Contact: Kate MacDonald
Phone: 02 9228 6435
Fax: 02 9228 6540
Email: kate.macdonald@planning.nsw.gov.au
Our ref: MP11_0046

Stage 3 Residential Development 61 Mobbs Lane, Epping (MP11_0046)

Attachment A

1 Site - Overall(Zoning)  
1:300

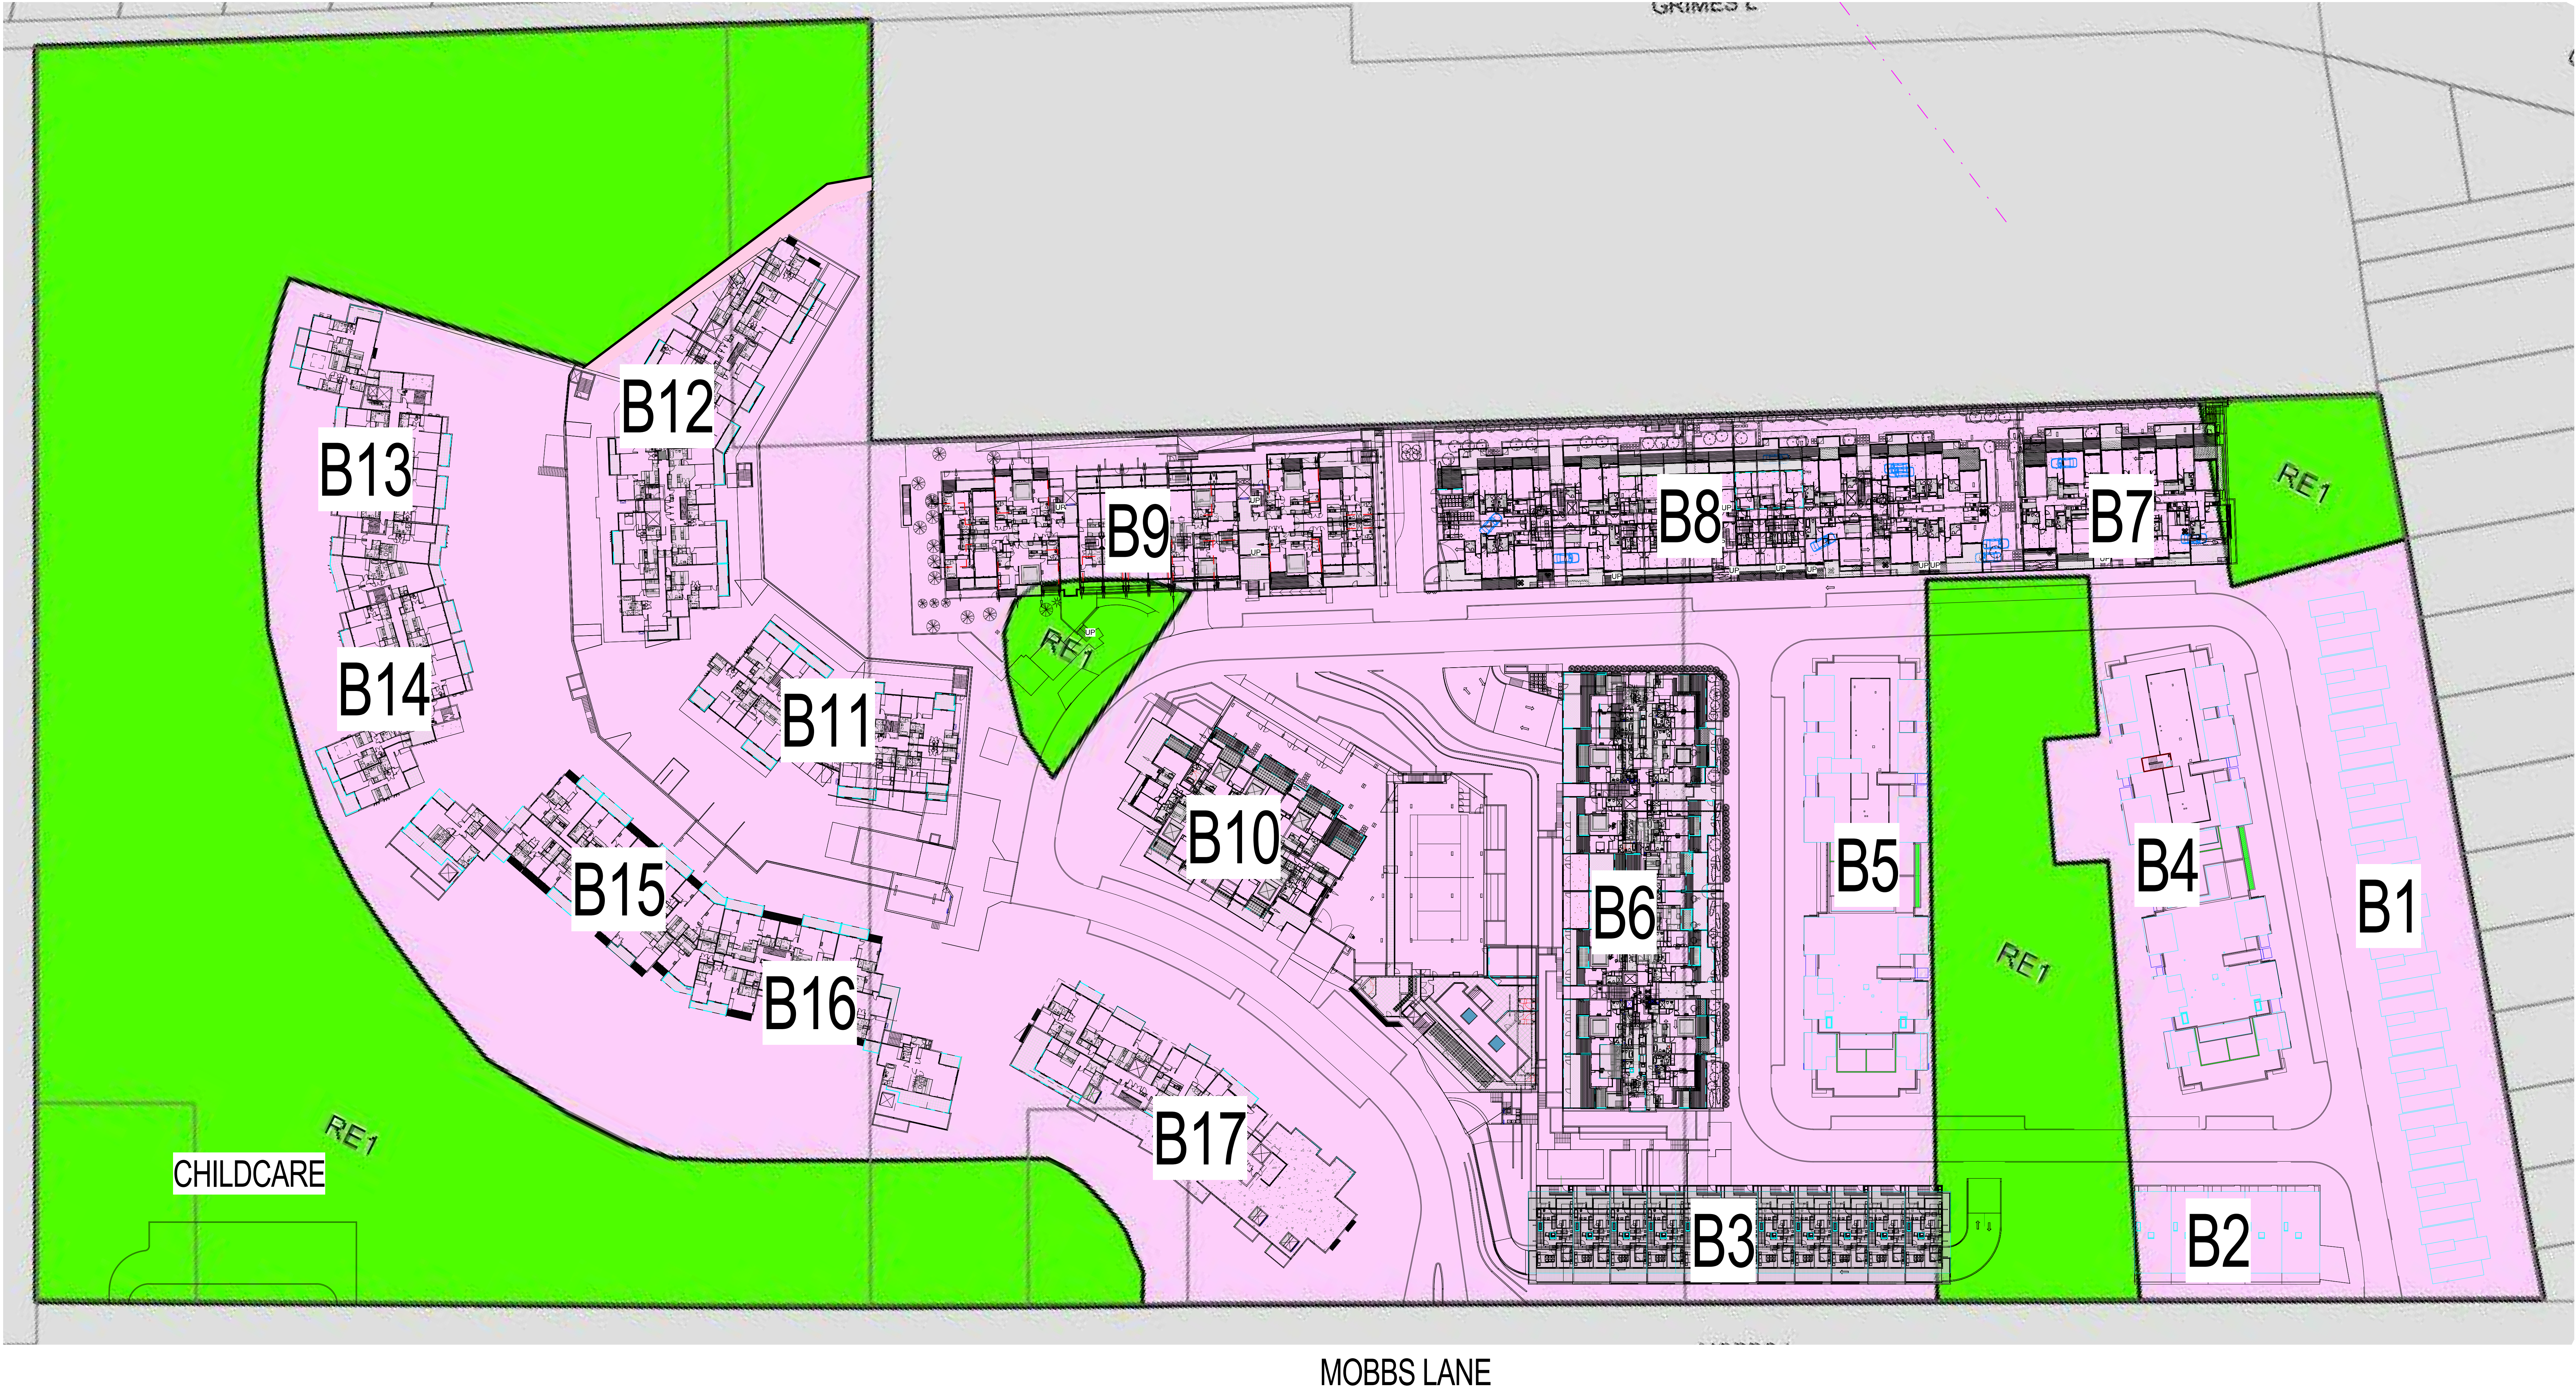
Based on a preliminary assessment of the drawings it appears that some of the structures may encroach into the 'public recreation' zone, which may result in permissibility issues. A zoning overlay plan is requested to verify whether the buildings and podia are contained within the 'residential' zone. Should any structures be located in the 'public recreation' zone, they are to be amended to be entirely within the residential zone.
